ASSESSMENT REPORT

Section 75W Modification

Lakes Estate Residential Subdivision, North Boambee Valley (MP 05_0129 MOD 1),
Coffs Harbour Local Government Area

Figure 6: Proposed Subdivision Plan

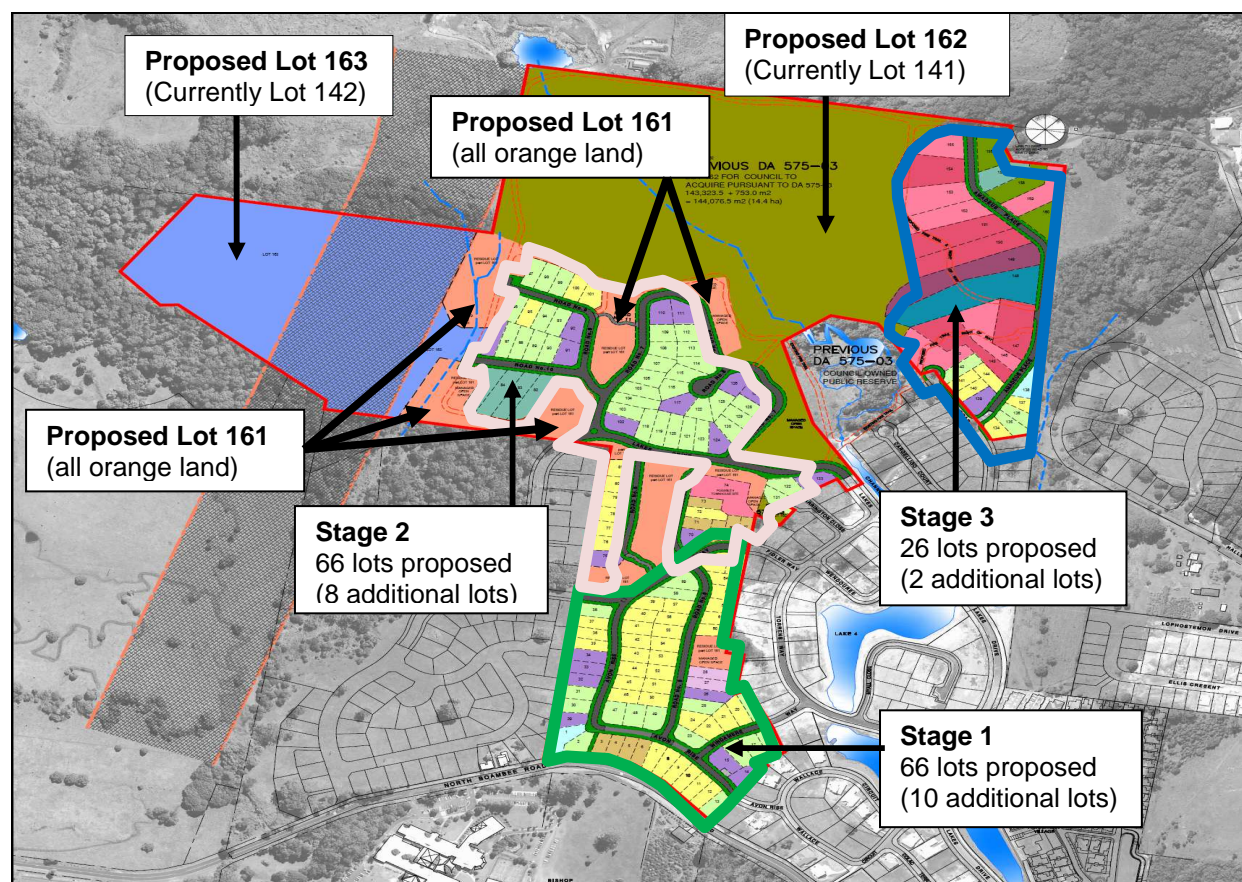
- the revised lot layout within Stage 3 is not supported on the basis that the revised design would require the clearing of additional Koala habitat and land within the Lowland Rainforest EEC buffer, and does not provide appropriate emergency access for emergency vehicles (i.e. the RFS).

- the fire trail proposed over lots 143, 145 to 155, and 162 is not supported as it is inconsistent with the requirements of *Planning for Bushfire Protection 2006* (PBP 2006), as the fire trails would extend over multiple private land holdings;
- if the link road between Amadeus Place and Kratz Drive is removed the Proponent should be required to provide an asset protection zone (APZ) along the eastern boundary of proposed Part Lot 160;
- the Proponent should demonstrate that appropriate APZs will be provided for lots 119 to 123, the land to the east of Stage 2D south of proposed Lot 131; and
- conditions B10, E3 and E5 of the Project Approval should be amended to reference the requirements of PBP 2006, and reflect the revised lot numbers for lots requiring the registration of a restrictive covenant for fire management purposes.

- the modification request does not include sufficient information to justify the proposed modifications to the layout of Stage 3.

Figure 7: Comparison of Approved and Proposed Subdivision Layout (Approved Layout Left, Proposed Layout Right)

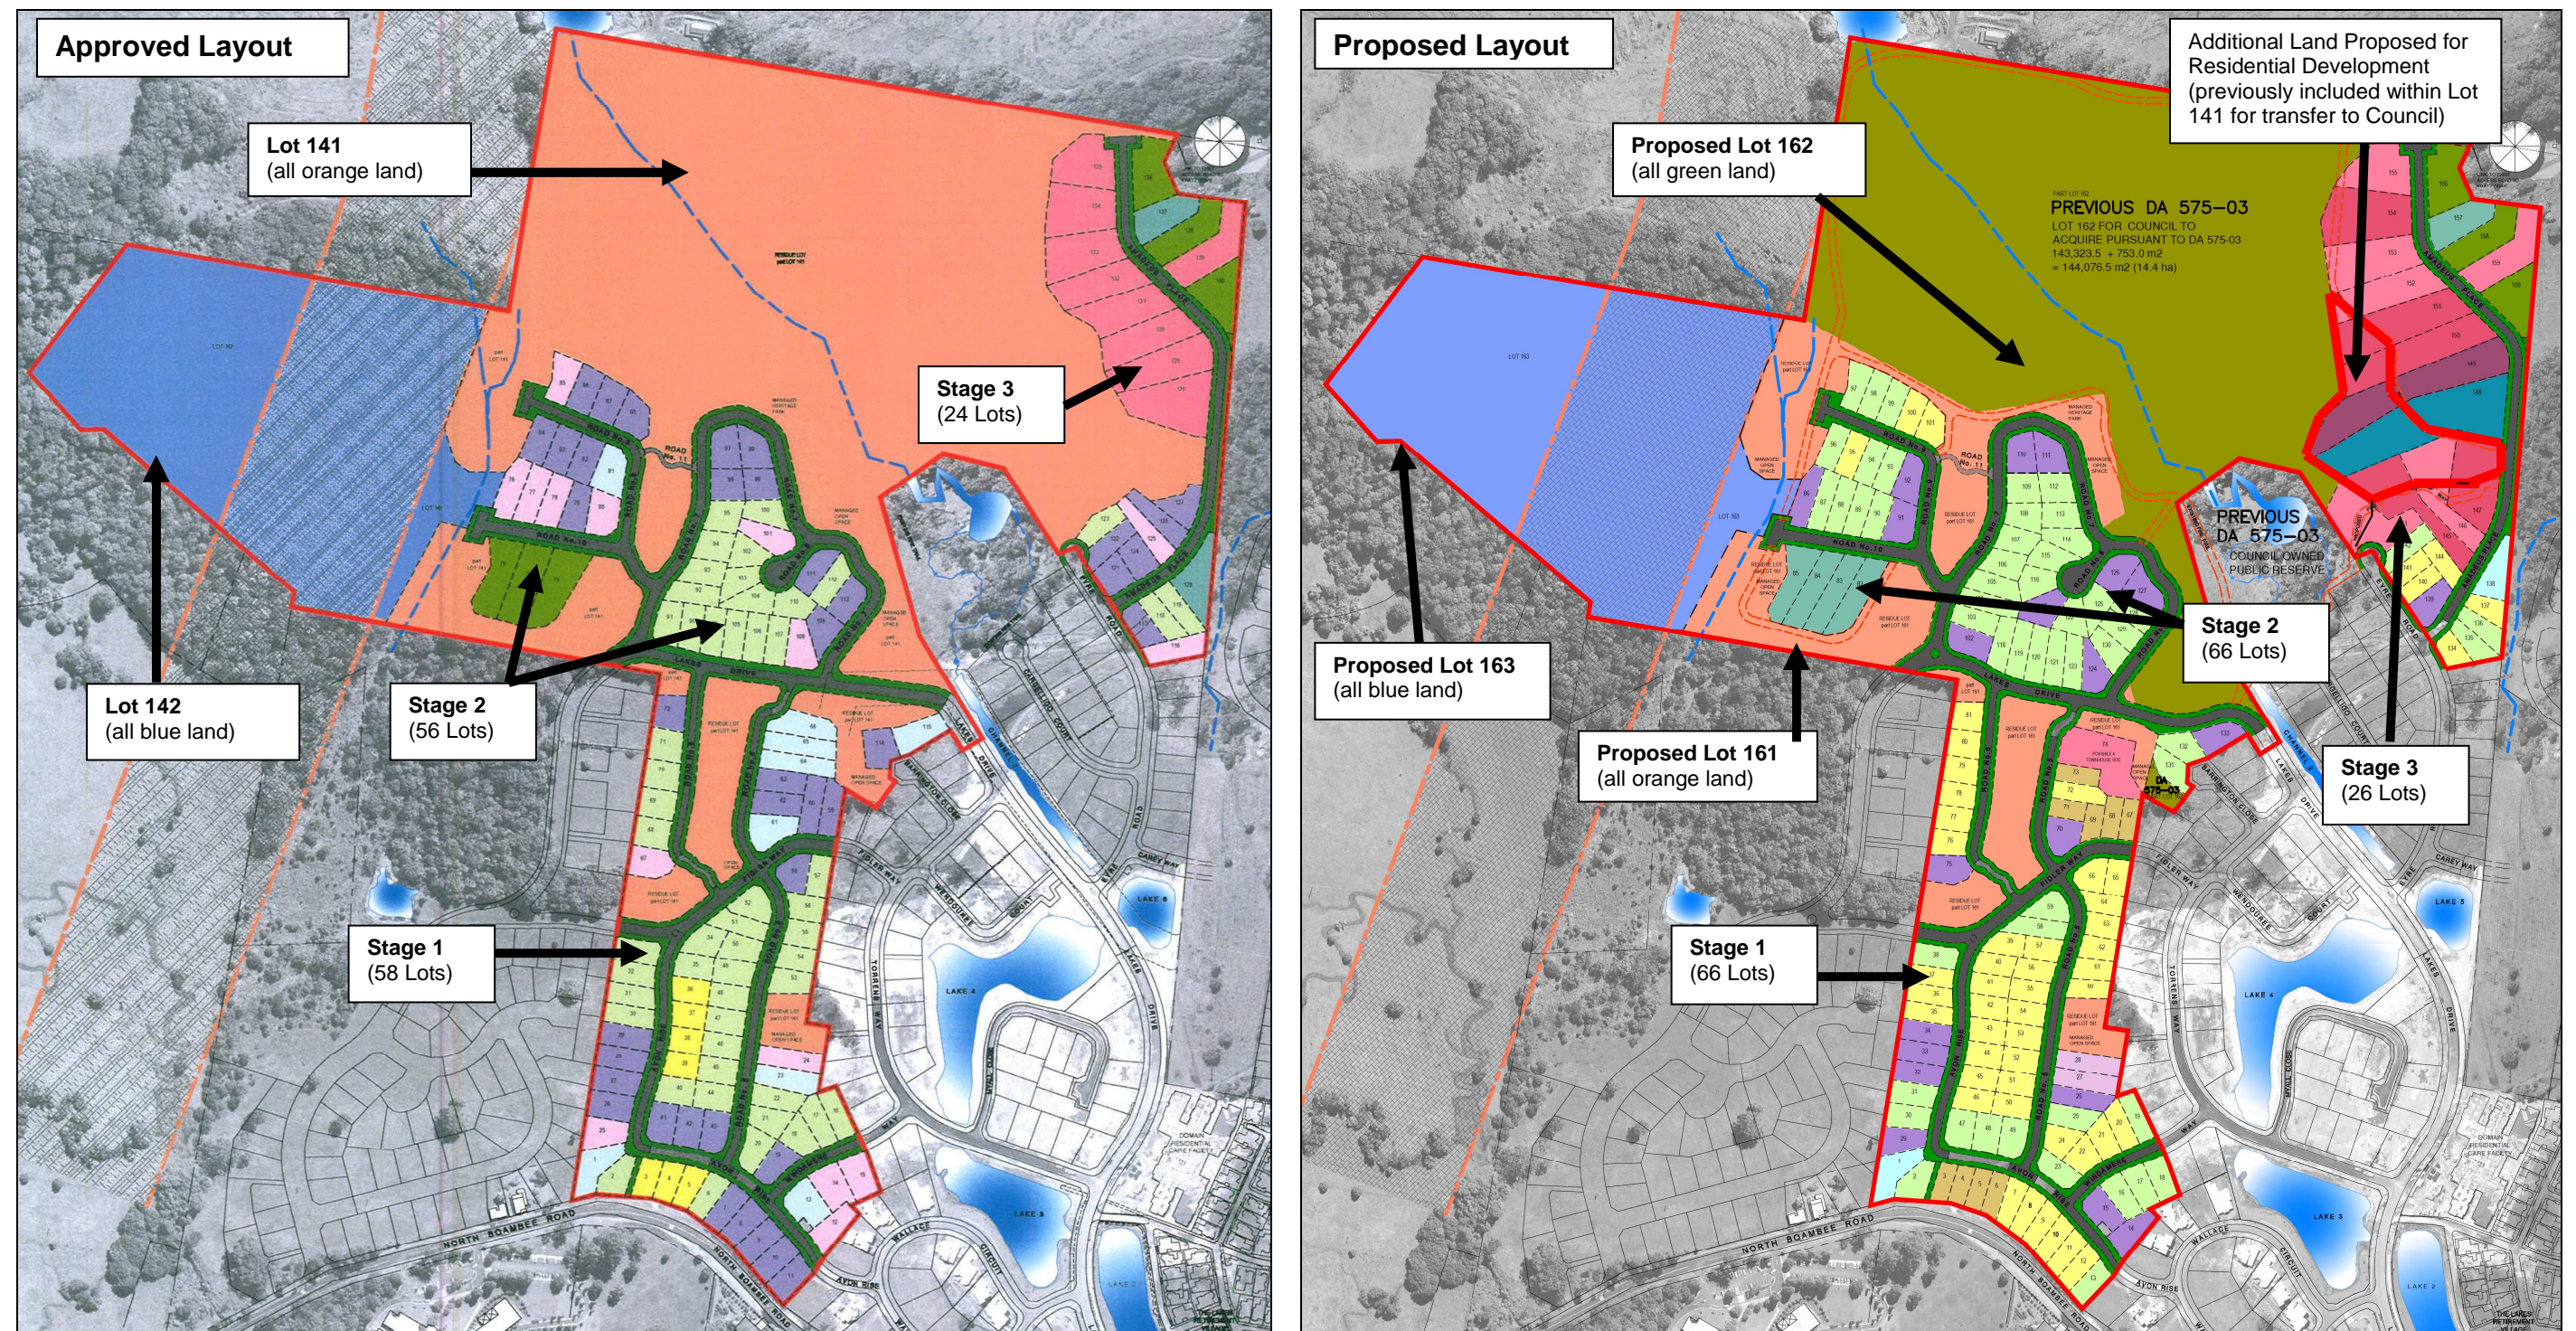
In terms of the proposed subdivision layout for Stage 3, the Department notes that the Council and the RFS raised concerns with the following aspects of the proposal:

- the potential need to clear primary and secondary Koala habitat and the potential reduction in the endangered ecological communities (EEC) protection buffer (see **Figure 8**);
- the proposed reduction in the size of Lot 141 (see **Figure 7** above); and
- the configuration of the proposed fire trails.

- the land within proposed lots 143 and 145 to 154 immediately west of the approved fire trail contains significant vegetation, and requiring multiple landowners to manage this land in-perpetuity is likely to result in a poor environmental outcome, particularly in

- whilst the modification request does not seek to alter the location of the fire trails approved within Stage 3, the proposed subdivision layout would result in the fire trails bisecting lots 143 and 145 to 154, which is inconsistent with the provisions of section 4.1.3(3) of PBP 2006.

In order to provide an appropriate environmental outcome, and ensure compliance with the requirements of PBP 2006, the Department has recommended a condition requiring all of the land to the west of the fire trail within Stage 3 to be incorporated into Part Lot 162. This will ensure the conservation and bush fire management outcomes are maintained as per the intent of the current Project Approval.

Figure 9: Pedestrian and Road Links Required under Condition B1(b) and (c)

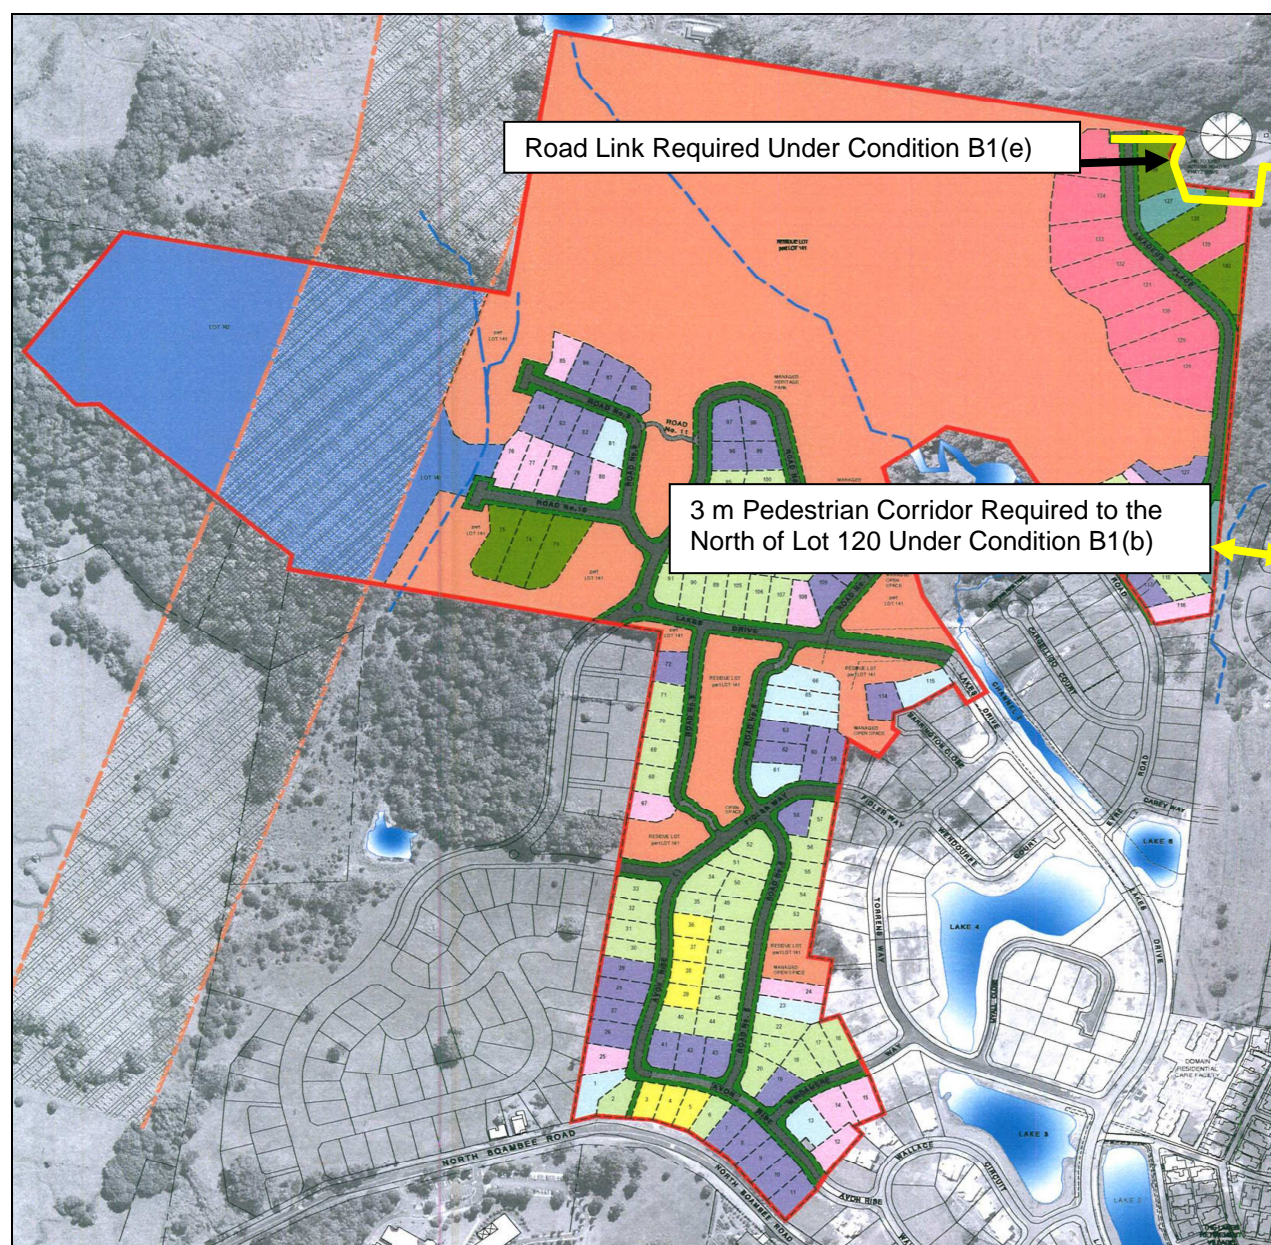
The Department notes that the Council and a number of local residents raised the following concerns with the deletion of the 3 m wide pedestrian corridor between the site and Halls Road:

- the removal of this connection would reduce the level of accessibility to the public open space within the Lakes Estate for residents east of Halls Road; and
- the removal of the pedestrian corridor would decrease permeability within the locality and would significantly increase the travel distance for children accessing Bishop Druitt College.

In addition, both the Council and the RFS raised concern with the removal of the road link between Amadeus Place and the Kratz Drive estate on the basis that the removal of this link would reduce accessibility for emergency vehicles, and the Proponent has not identified a viable alternate access route.

- the road link between Amadeus Place and Kratz Drive was required to ensure emergency service vehicles could access the residential lots within Stage 3B in the event of a bush fire, and no viable access has been proposed by the Proponent. Accordingly, its removal is not supported; and
- the removal of the pedestrian corridor connecting the site to Halls Road is inappropriate as it will significantly reduce pedestrian connectivity within the locality, particularly for school students attending Bishop Druitt College (see **Figure 10**). Given the above, the Department does not support the removal of this connection.
